Application Ref:	3/2020/1061	 Ribble Valley Borough Council www.ribblevalley.gov.uk	
Date Inspected:	12/02/2021		
Officer:	AB		
DELEGATED ITEM FILE REPORT:		Decision	REFUSED

Development Description:	Proposed erection of a seven-bedroom holiday cottage.
Site Address/Location:	Pendle View Primrose Lane Mellor BB2 7EQ

Materials Key:

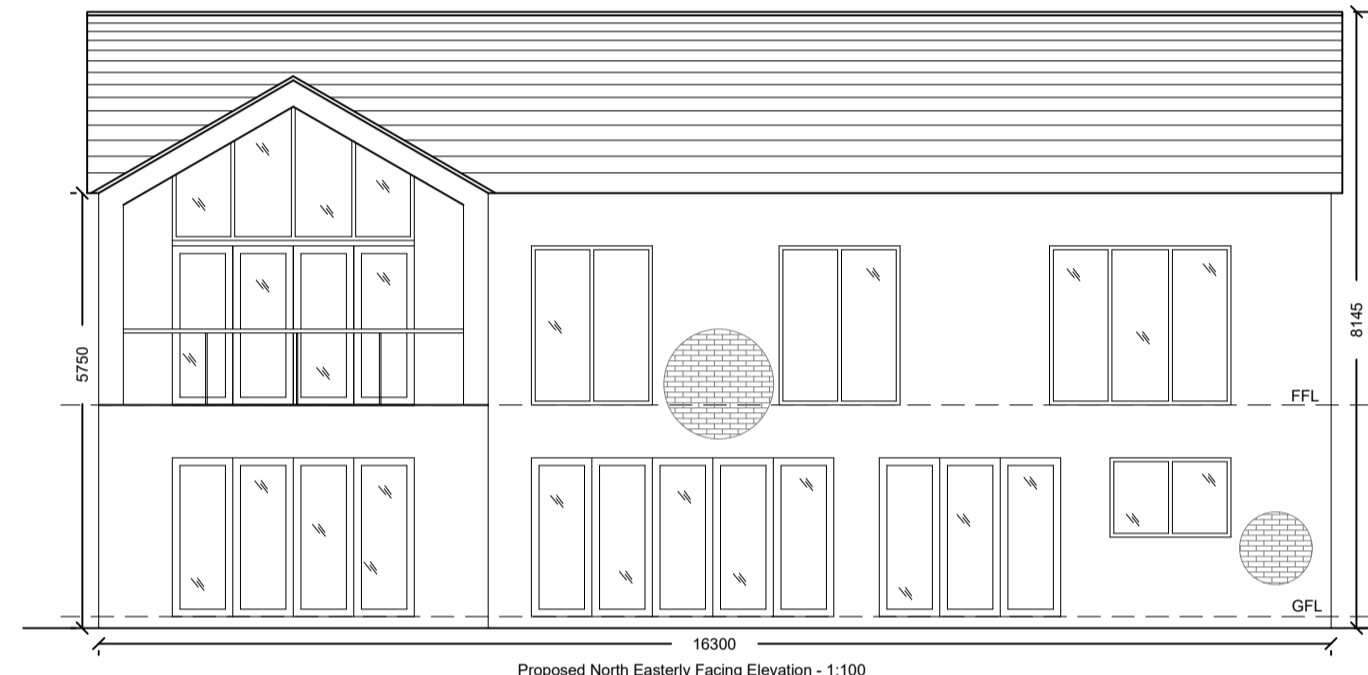
The proposed building would be around 8.2m high to the ridge and would be faced with brick and slate and powder coated aluminium windows and doors. The proposed building would be tilted at an angle compared with Pendle View and would be orientated such that its principal elevation would be south-west facing, opposite the orientation of Pendle View. The principal elevation would have three front-facing gables, the central gable being heavily glazed from ground level to the apex. The rear elevation would have significant glazed elements and would include an external first floor balcony with glass balustrade. The footprint of the building would measure approximately 16 x 12 metres.

With regard to the complex of 12 holiday lodges on land to the rear, it was considered that due to their size and single storey height the development would not result in an unacceptable visual impact. What is proposed in this case is a substantial permanent new two storey building that would be clearly visible from the surrounding roads. The building is proposed to be faced in brick yet the majority of buildings in the immediate area are constructed from natural stone.

In terms of the buildings design, it fails to reflect local vernacular style which includes the use of traditional materials and simple elevational language. The introduction of large glazed elements which includes openings of both vertical and horizontal emphasis and a glazed first floor balcony, results in a poor design and a building that would be a prominent and incongruous addition to this open countryside area.

In addition, the proposals include a generous curtilage area that would be used as garden. This area is significantly larger than would normally be expected for holiday accommodation and would contribute to the harm arising from the scheme as a whole. The site plan indicates the provision of parking for three vehicles. However, the building proposed does not fall into the C3 use class and therefore residential parking standards are not considered applicable in this instance. The County Surveyor (Highways) advises that there is likely to be a requirement to provide up to 7 parking spaces (1 per room) if assessed in a similar way to a hotel for example. The provision of a parking area for up to 7 vehicles would also clearly contribute towards the visual impact of the development but also indicates the potential intensity of the use.

As such, it is considered that, due to the size, scale, design and elevational language of the proposed building, and the extent of garden curtilage proposed, the development would have a considerable negative visual impact and would be contrary to Key Statement EN2 and policies DMG1, DMG2 and DMH3.

1. The proposed development, as a result of its scale and design, would be contrary to Core Strategy Policy DMG2 which requires tourism and recreational developments in the open countryside to be 'small-scale' and 'appropriate to a rural area'.
2. The proposed development, by virtue of its scale, siting, layout and design, would result in an incongruous and prominent addition in this open countryside location that would be harmful to the visual amenity of the area contrary to Key Statement EN2 and Policies DMG1, DMG2 and DMB3 of the Ribble Valley Core Strategy.
